BUILDING CODE OF AUSTRALIA COMPLIANCE ASSESSMENT REPORT

PROPOSED MIXED USE DEVELOPMENT

175-177 CLEVELAND STREET & 1-5 WOODBURN STREET, REDFERN

REPORT NO. ► 5567 – REV 02

GROUND / LEVEL 1 CONCEPT

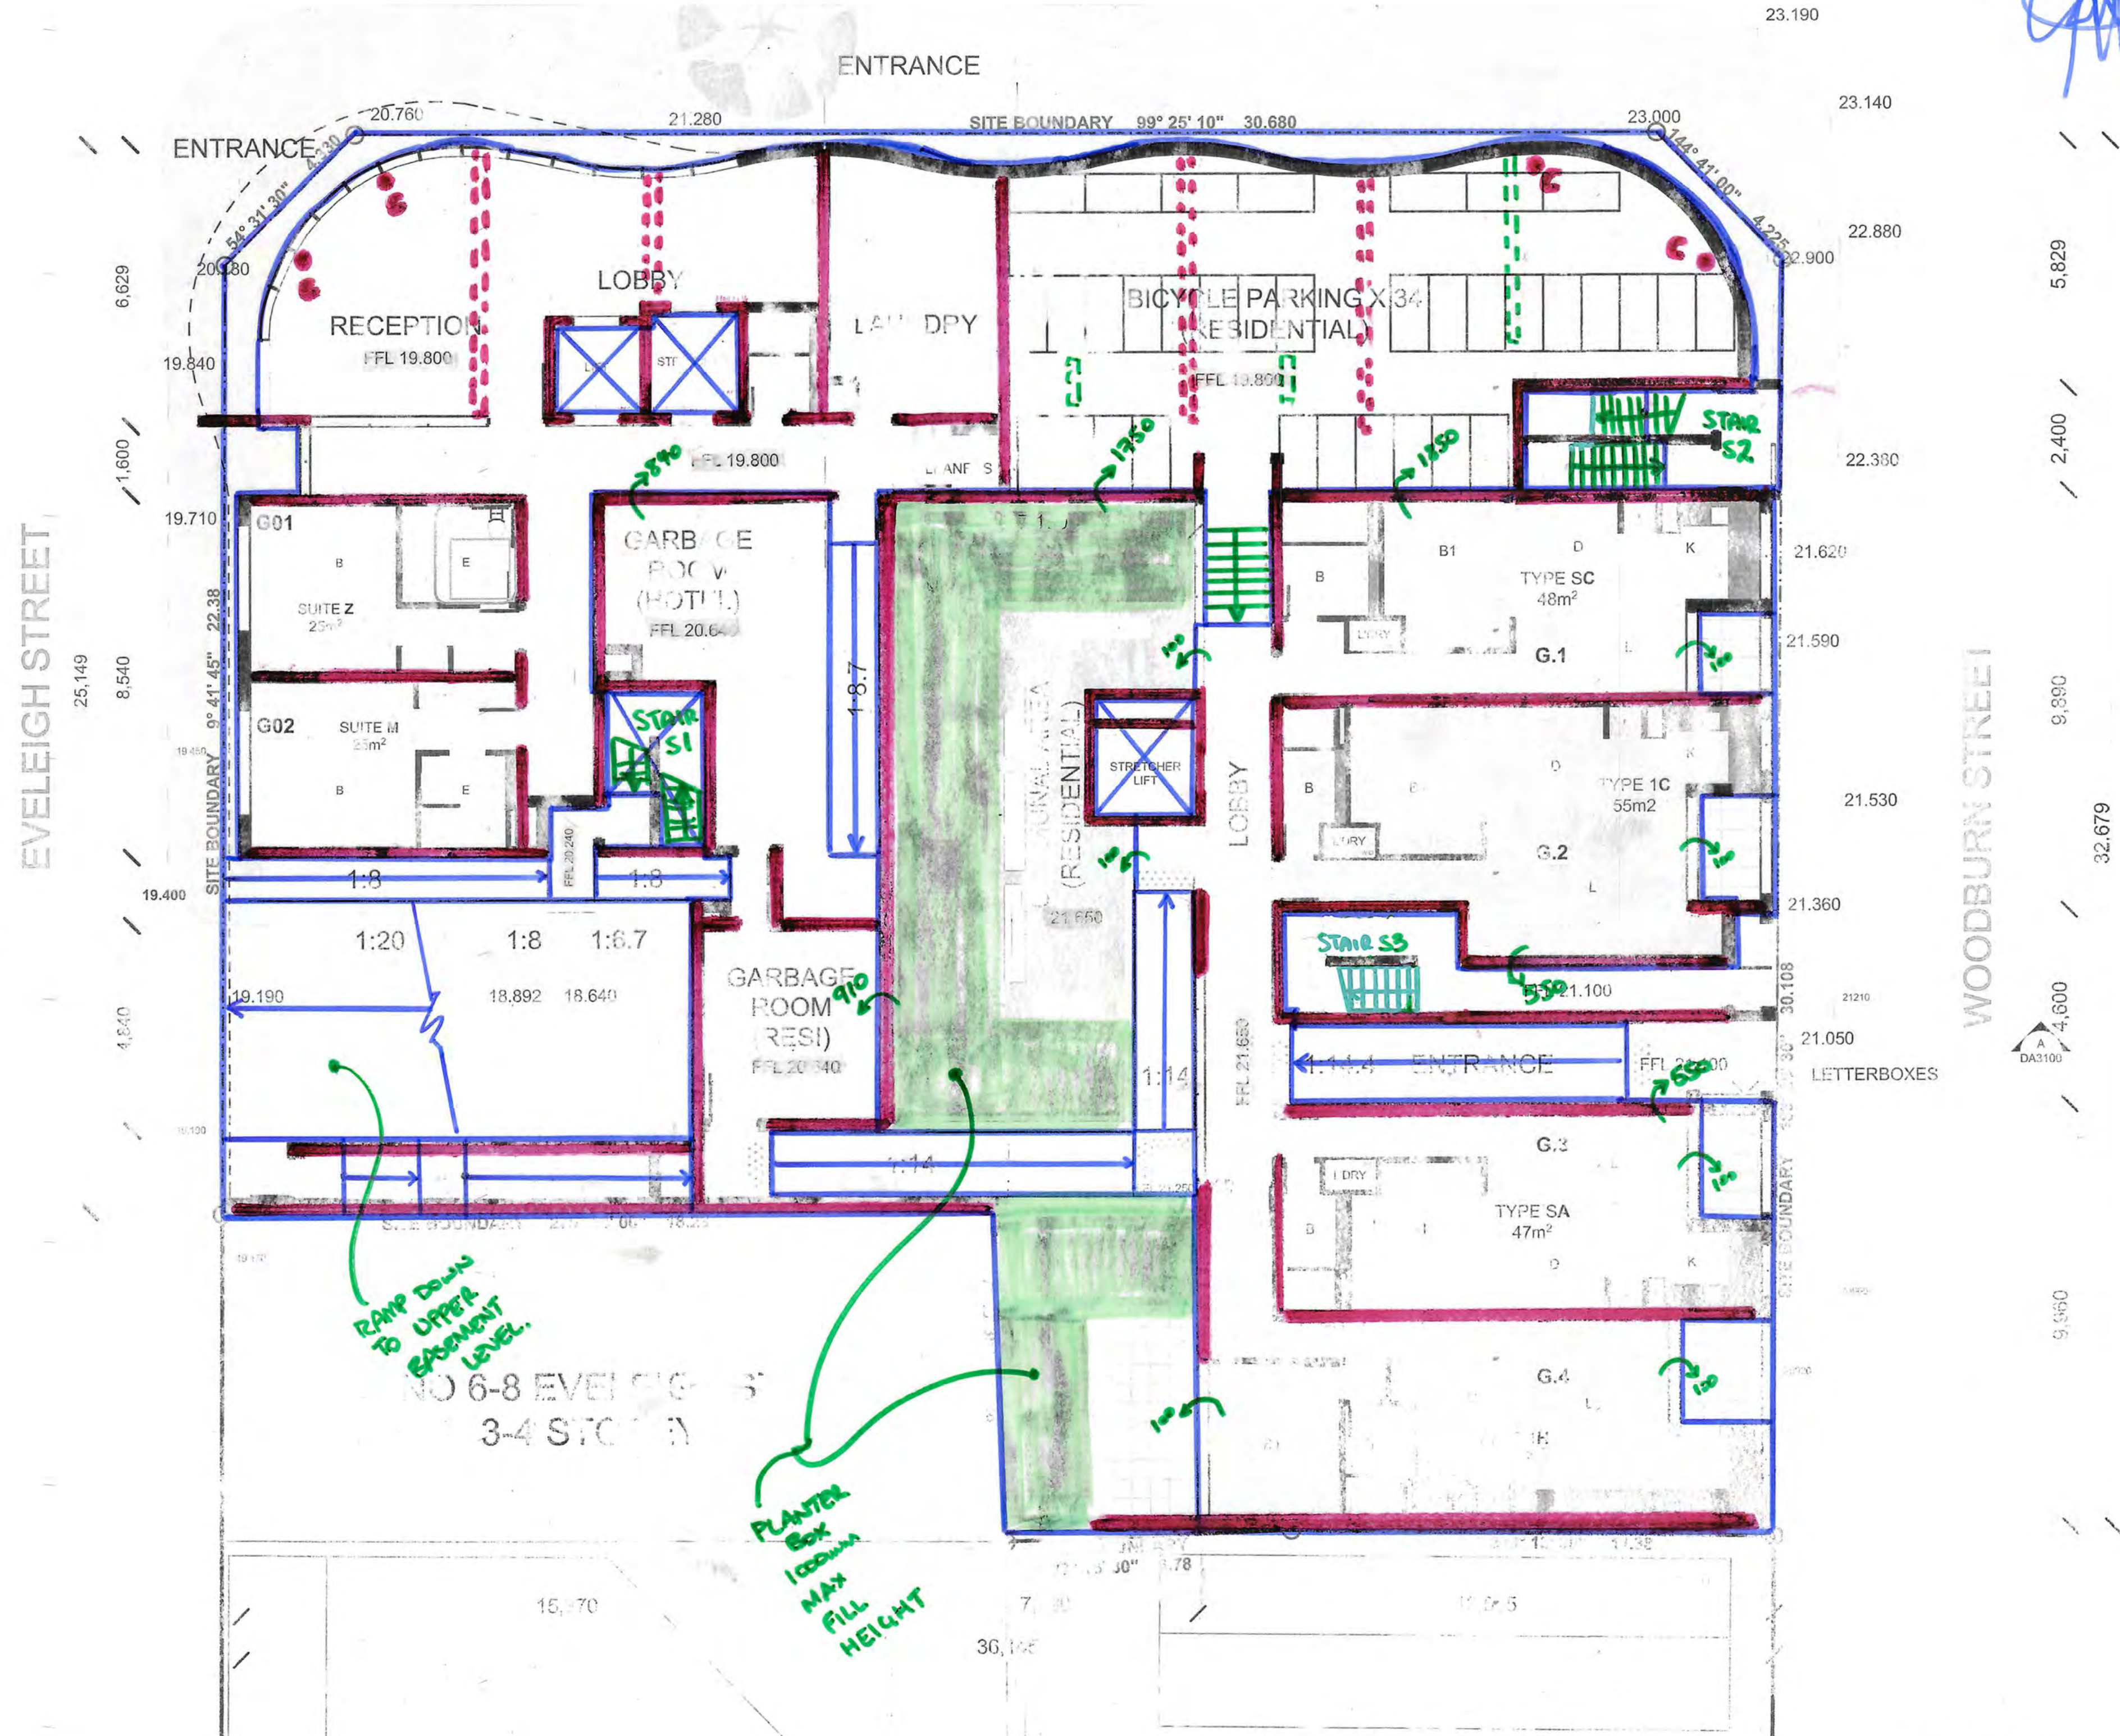
BCA Clause	Deemed-to-Satisfy Provision to be addressed
D1.4 Exit Travel Distances	<p><u>Compliance issue(s):</u></p> <ol style="list-style-type: none"> The travel distance to a point of choice to two alternate exits from the ground level bicycle parking store is more than 20m (27m noted) <p><u>Recommendation(s)</u></p> <p>Architect must either update the plans to demonstrate compliance with the requirements of this BCA Clause or seek to engage a fire engineer to provide an alternative solution to satisfy the BCA performance criteria where DTS compliance is unattainable.</p>
D1.7 Travel via Fire Isolated Stairs	<p><u>Compliance issue(s):</u></p> <ol style="list-style-type: none"> The western fire stairs serving basement and upper levels discharge inside ground floor / level 1 in lieu of discharging onto an area that is permitted under D1.7(b). The occupants discharging from the eastern fire serving both the lower and upper basement levels are required to pass adjacent to the fire stair discharge door serving the class 3 hotel tower. Hence under the requirements of this clause, the discharge door to the fire stair serving the residential tower is required to be fire rated in accordance with BCA Clause C3.4. Where the fire stair serving the class 2 residential tower discharges onto a covered area, this must achieve a clear height of not less than 3m. <p><u>Recommendation(s)</u></p> <p>Architect must either update the plans to demonstrate compliance with the requirements of this BCA Clause or seek to engage a fire engineer to provide an alternative solution to satisfy the BCA performance criteria where DTS compliance is unattainable.</p>
